From: Adrian Dowd
Sent: 03 February 2022 12:34
To: Planning
Cc: Nicola Hopkins; John Macholc
Subject: RE: Consultation on planning application, 3/2021/0275, Land Behind the Dog Inn Market Place Longridge PR3 3RR

The application is for - Proposed erection of 9 new dwellings and associated works.

Figure 11) Conservation Area map (extract) – the boundary is red and the dotted red line is a suggested extension

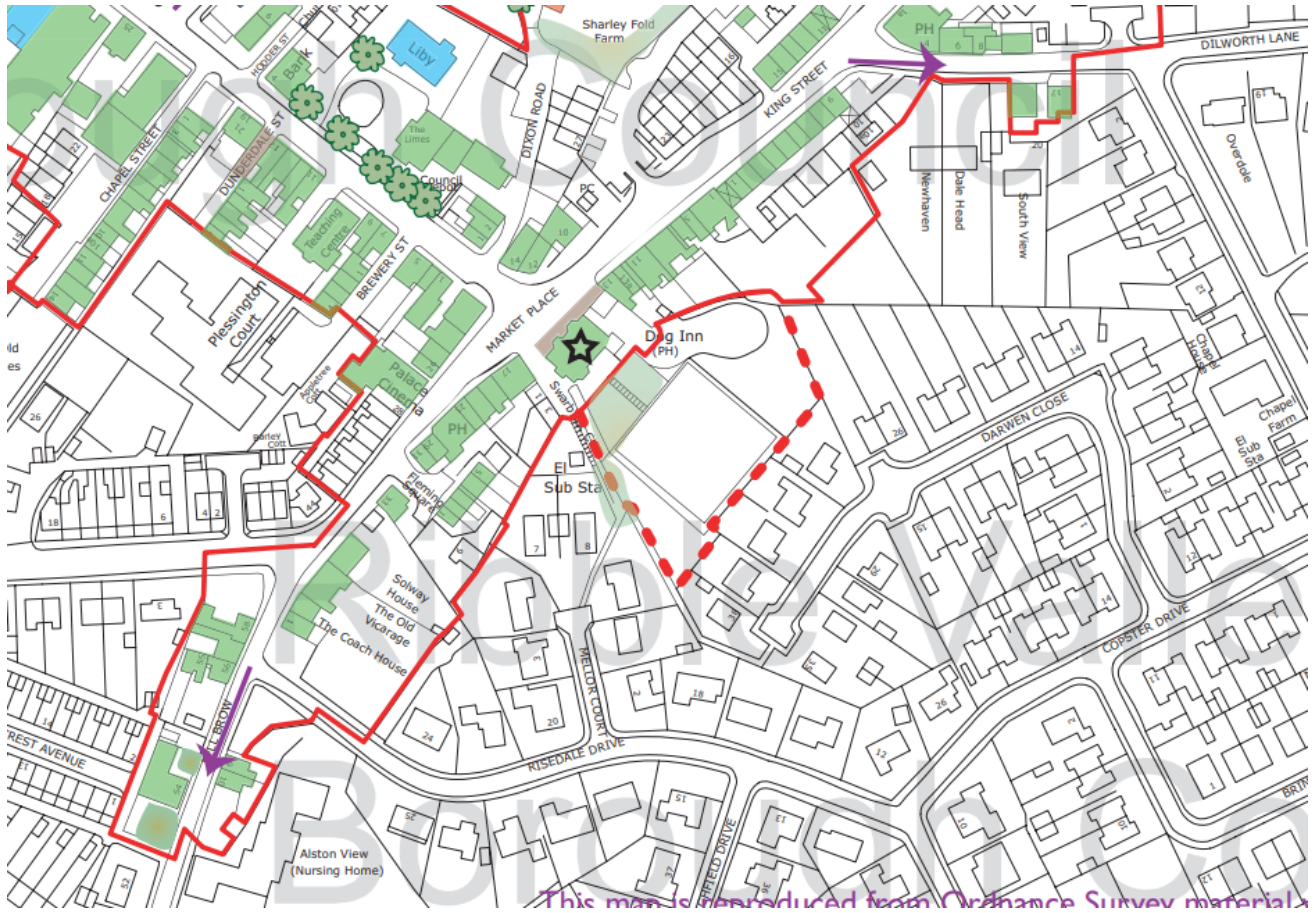
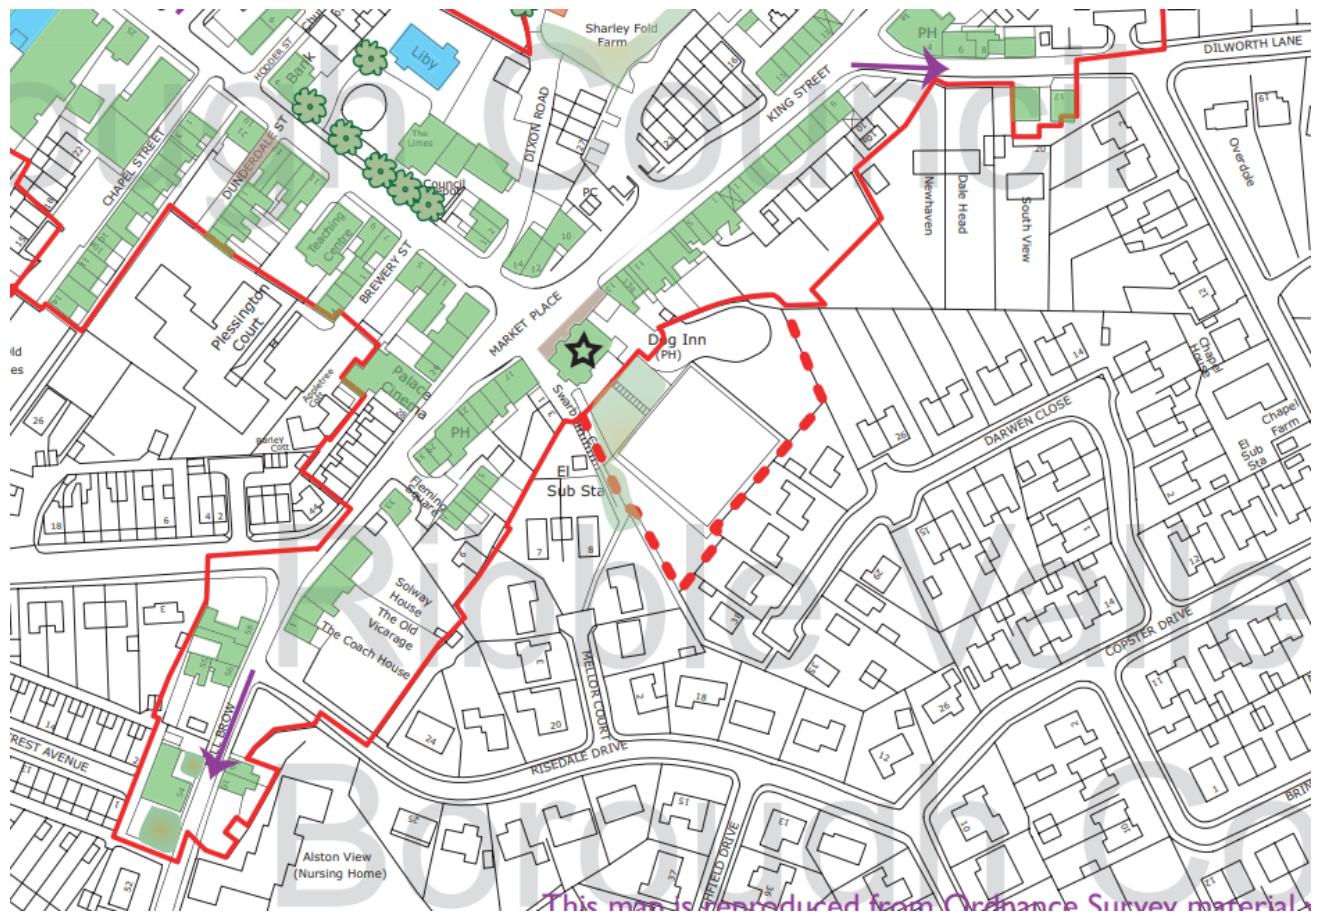
The site area is very similar to the extension to the Longridge Conservation Area designated by the Borough Council following public consultation on 3 April 2007. Whilst the Appraisal does not outline reasons for designation, this area is important to the setting of the Dog Inn which is identified as a Focal Building (its rear elevation is of interest) and Building of Townscape Merit. This open area is also important to the setting of the row of Buildings of Townscape Merit on King Street and Market Place - retaining their architectural and historic stature and visibility and preventing the encroachment of modern development on the designated heritage asset. The Heritage Statement confirms "The site does provide vantage points to see the rear of the Dog Inn and adjacent C19th houses, therefore retains some potential benefits particularly in regard to views of the Inn's attractive and prominent rear elevation" (3.11) and "Dog Inn, which is a building of notable architectural quality with some landmark appeal" (3.15).

I am initially concerned (no site inspection undertaken) because this area of land was specifically incorporated into Longridge Conservation Area for its special architectural and historic interest following the review by The Conservation Studio consultants:
